Recommendation Report for Planning Permission for Works or Extension to a Dwelling

REF NO: BE/13/26/HH

LOCATION: 40 Greencourt Drive
Bersted
PO21 5EU

PROPOSAL: Proposed construction of a single-storey rear and side (wrap-around) extension to the existing detached dwellinghouse, with a flat roof and external brick slip cladding.

ADDRESS	40 Greencourt Dr, Bognor Regis PO21 5EU, UK
TITLE	FLOOR PLANS
PROJECT STATUS	PLANNING DRAWINGS
DATE	JAN 2026
REVISION	
SCALE	As Indicate @A1
SHEET No.	WD001
REFERENCE	0010/20/FA
DRAWN BY

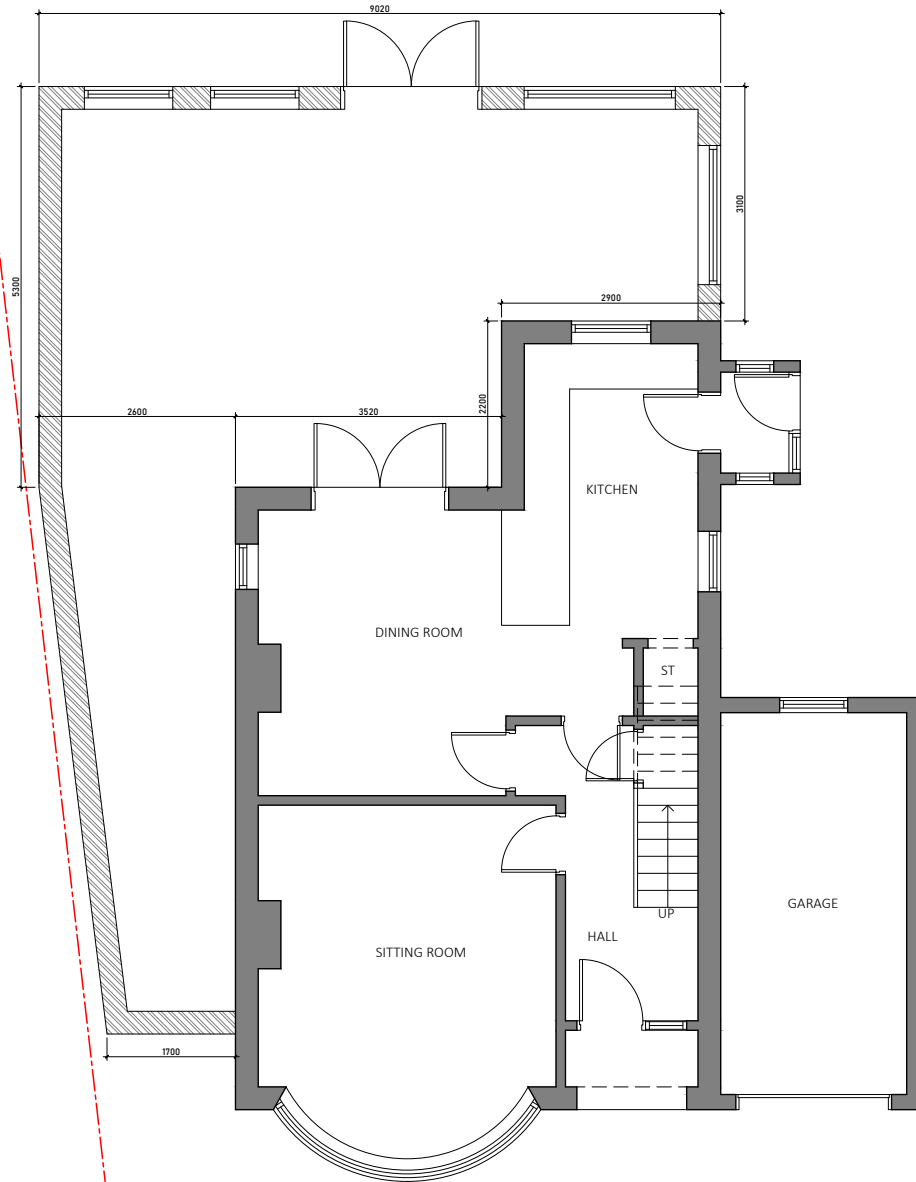
The proposed single storey side and rear extension would wrap around the side (east) and rear (south) elevations of the host dwelling. The proposed extension would have a width of 1.7m to the front and a total width across the rear of 9m. At its maximum depth, the proposal would extend 5.3m beyond the recessed aspect of the rear elevation and 3.1m beyond the deepest point of the rear elevation. The proposal would have a flat roof form with a height of 3.1m and an eaves height of 2.9m. Set within the flat roof would be two rooflights with a height of 3.3m and a large roof lantern with a height of 3.7m. This would result in a large footprint that would not be subservient to the host dwelling.

The proposed side extension would be set back 1m from the existing front elevation of the host dwelling and the side extension would comply with the Arun Design Guide (ADG) in this regard. In relation to the rear aspect of the extension, the guidance set out in the ADG advises a maximum depth of 3.3m for a single storey extension. The proposed extension would extend beyond this by 2m to a depth of 5.3m from the recessed projection of the rear elevation, however it would extend 3.1m beyond the existing deepest part of the rear elevation. Whilst the depth of the rear extension would not strictly accord with the guidance outlined within the ADG, the extension would be located to the rear of the host dwelling and would not be visible from the street scene. It is further noted that there is existing variation in form and scale of side and rear extensions within the surrounding area and the host dwelling would retain a rear garden depth in excess of 25m. Therefore, on balance, the proposal would not result in harm to the character or appearance of the host dwelling, street scene or wider area.

It is noted that the single storey side (east) extension would be set in approximately 0.2m from the neighbouring side boundary and would not comply with the minimum guidance of 1m as outlined in the Part M of the ADG. However, at its deepest point, the separation distance would increase to 1m, which is comparable to the separation distance between neighbouring properties. Existing high boundary treatments would be retained, and it is noted that the neighbour to the east is orientated such that the rear elevation of this neighbour faces away from the application site. Therefore, the proposal would not result in significant overbearing or overshadowing impacts to this neighbour. Given the spacing maintained between the proposed rear extension and the neighbour to the north west, the proposal would not result in any overbearing or overshadowing impacts to this neighbour.

ADDRESS	40 Greencourt Dr, Bognor Regis PO21 5EU, UK
TITLE	FLOOR PLANS
PROJECT STATUS	PLANNING DRAWINGS
DATE	JAN 2026
REVISION	
SCALE	As Indicate @A1
SHEET No.	WD002
REFERENCE	0010/20/FA
DRAWN BY

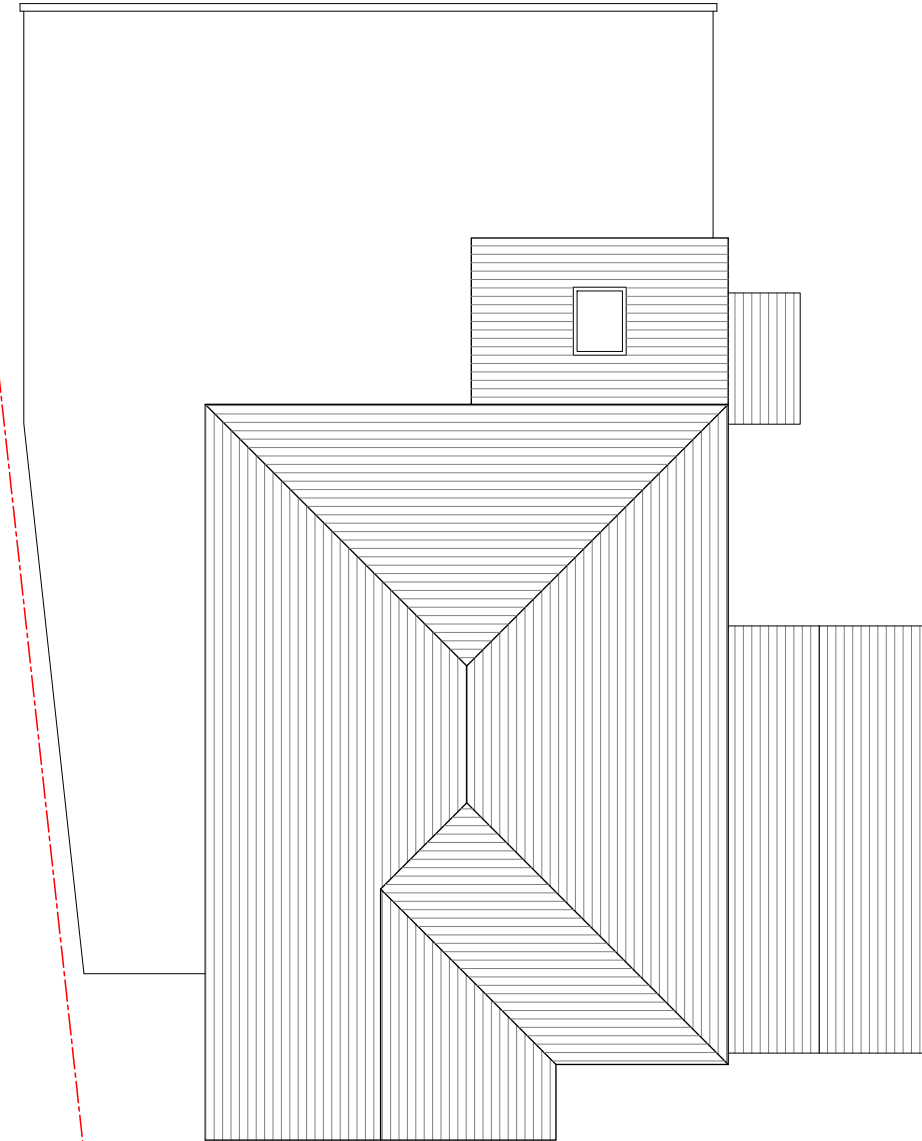
The rear (south) elevation would feature three two-casement windows and a double door. The flat roof would include one rooflight on the eastern side, and the flat roof over the rear extension would incorporate one double-glazed roof light and a large roof lantern.

The rear fenestration (south) would have an outlook of the rear garden amenity serving the host dwelling and the rooflights and roof lantern would accord with Part M of the ADG. Therefore, the proposed fenestration would not result in loss of privacy or overlooking to the neighbouring dwellings.

ADDRESS	
40 Greencourt Dr, Bognor Regis PO21 5EU, UK	
TITLE	
ELEVATIONS	
PROJECT STATUS	
PLANNING DRAWINGS	
DATE	JAN 2026
REVISION	A
SCALE	As Indicate @A1
SHEET No.	WD003
REFERENCE	0010/20/FA
DRAWN BY

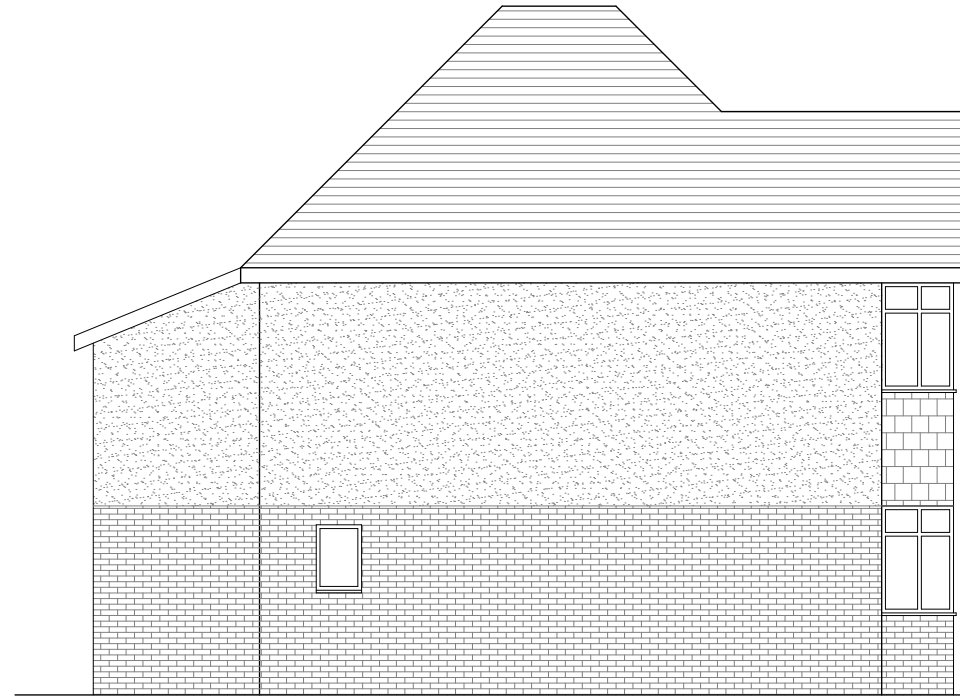
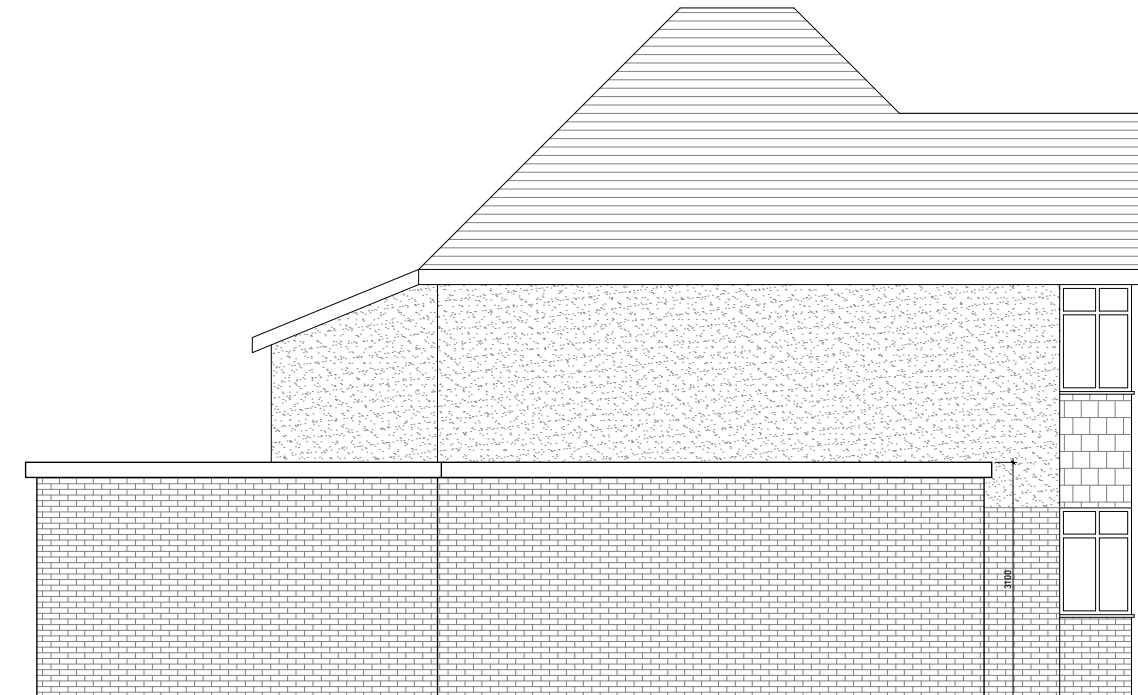
Amended plans have been received during the course of this planning application which include the change of the originally proposed materials from cladding to Rustic Red Charcoal Multi 685 brick slip to match the existing dwelling.

The proposal would be finished in a brick slip Rustic Red Charcoal Multi 685 to match the existing and the flat roof would be finished in an EPDM rubber membrane system. This would ensure the extension would integrate appropriately with the host dwelling, responding to the character of the site and its local surroundings as set out in BNP policy ES1. As a result, the development would not result in any harm to visual amenity, character or appearance of the host dwelling, street scene, or wider area, and the proposal is in accordance with Arun Local Plan policies D DM1 and D DM4, the ADG and BNP policy ES1.
